COMMUNITY SERVICES DEPARTMENT

November 9, 2018

Subject: Sterling Ranch Sketch Plan Amendment, Review #2 (SKP-18-003)

STERLING RANCH SKETCH PLAN AMENDMENT

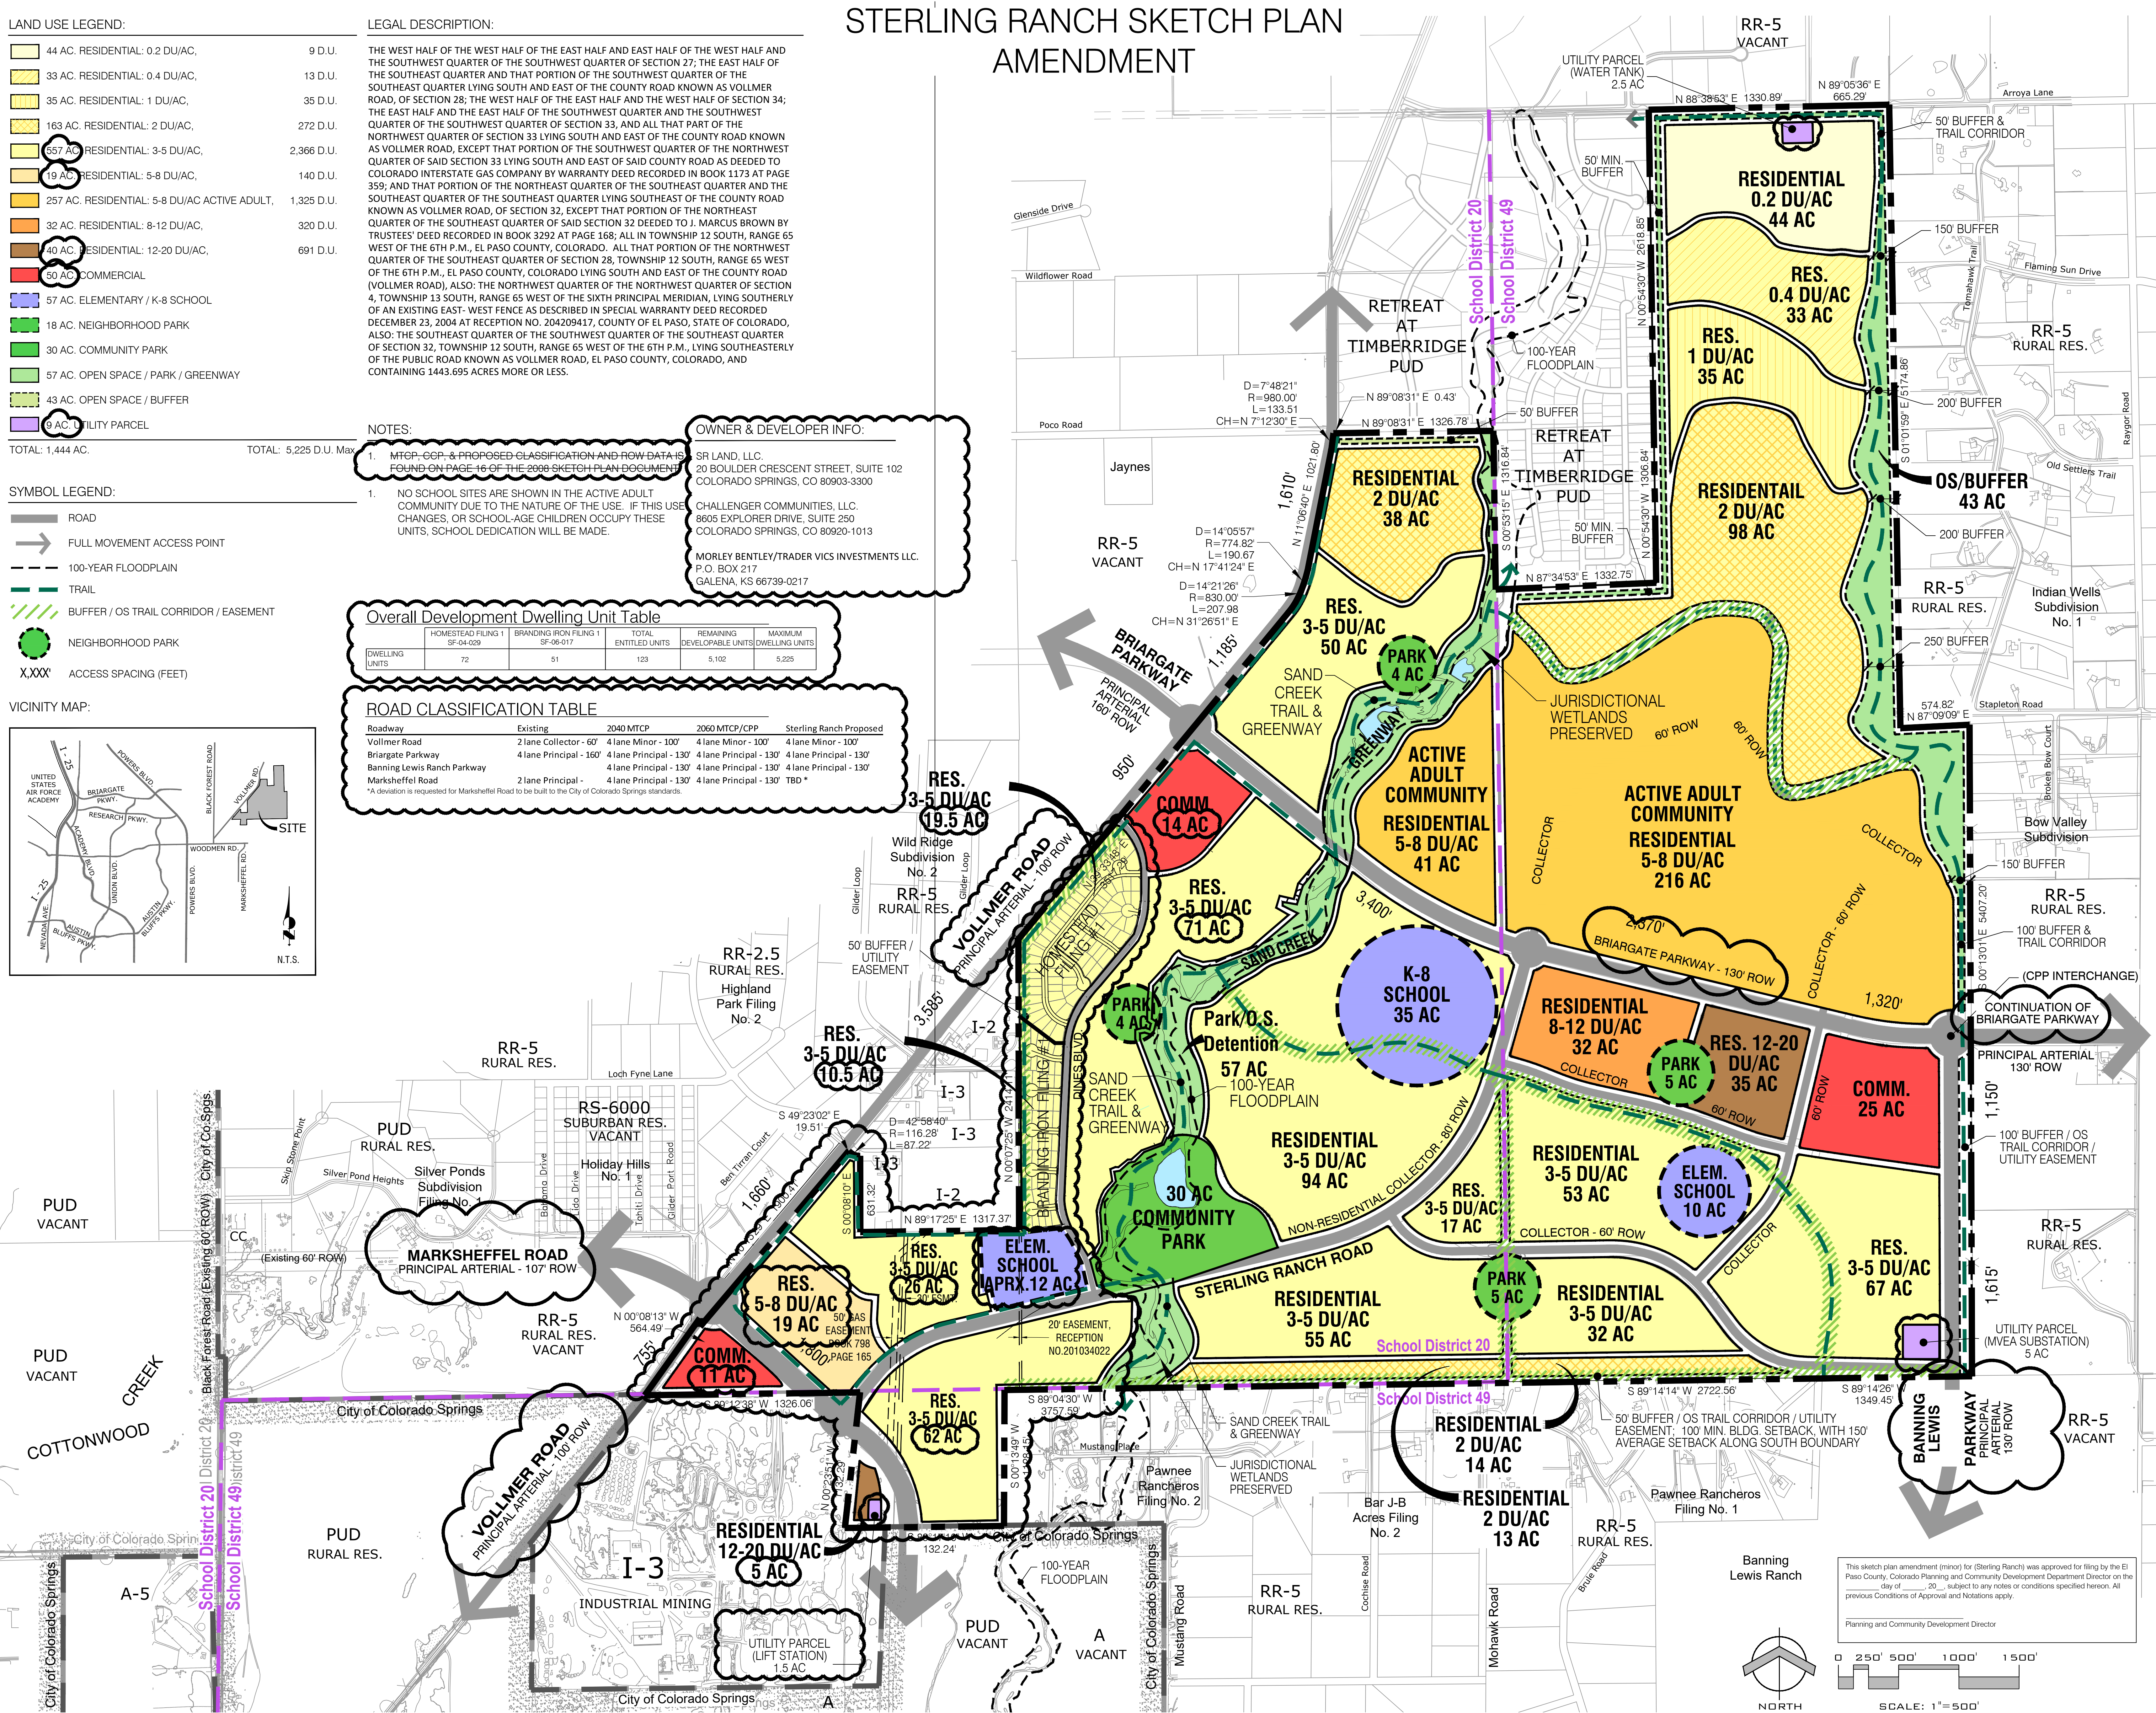
Staff recommends that the developers designate and provide to El Paso County 25-foot trail easements along the remaining sections of Sand Creek, as well as along the southern side of Arroyo Lane for the purpose of construction and maintenance of the Sand Creek Regional Trail and the Arroyo Lane Regional Trail, respectively. Staff also encourages the developers to construct the aforementioned proposed neighborhood and community parks, so as to provide recreational opportunities for residents and visitors of Sterling Ranch. Furthermore, staff encourages the developers to construct internal trail systems that link residents not only to the proposed neighborhood and community parks, but also to the County's regional trail system.

Recommend to the Planning Commission and the Board of County Commissioners that the approval of Sterling Ranch Sketch Plan Amendment includes the following conditions: (1) designate and provide to El Paso County a 25-foot trail easement along the Sand Creek corridor, that allows for public access, as well as construction and maintenance by El Paso County of the Sand Creek Regional Trail, (2) designate and provide to El Paso County a 25-foot trail easement along south side of Arroyo Lane, that allows for public access, as well as construction and maintenance by El Paso County of the Arroyo Lane Regional Trail, (3) the easements shall be shown on all forthcoming preliminary plans and final plats, and the aforementioned easements shall be dedicated to El Paso County on the forthcoming final plat(s), (4) fees in lieu of land dedication for regional and urban park purposes will be calculated upon review of forthcoming preliminary plans and final plats, and will be required at time of the recording of the forthcoming final plats."
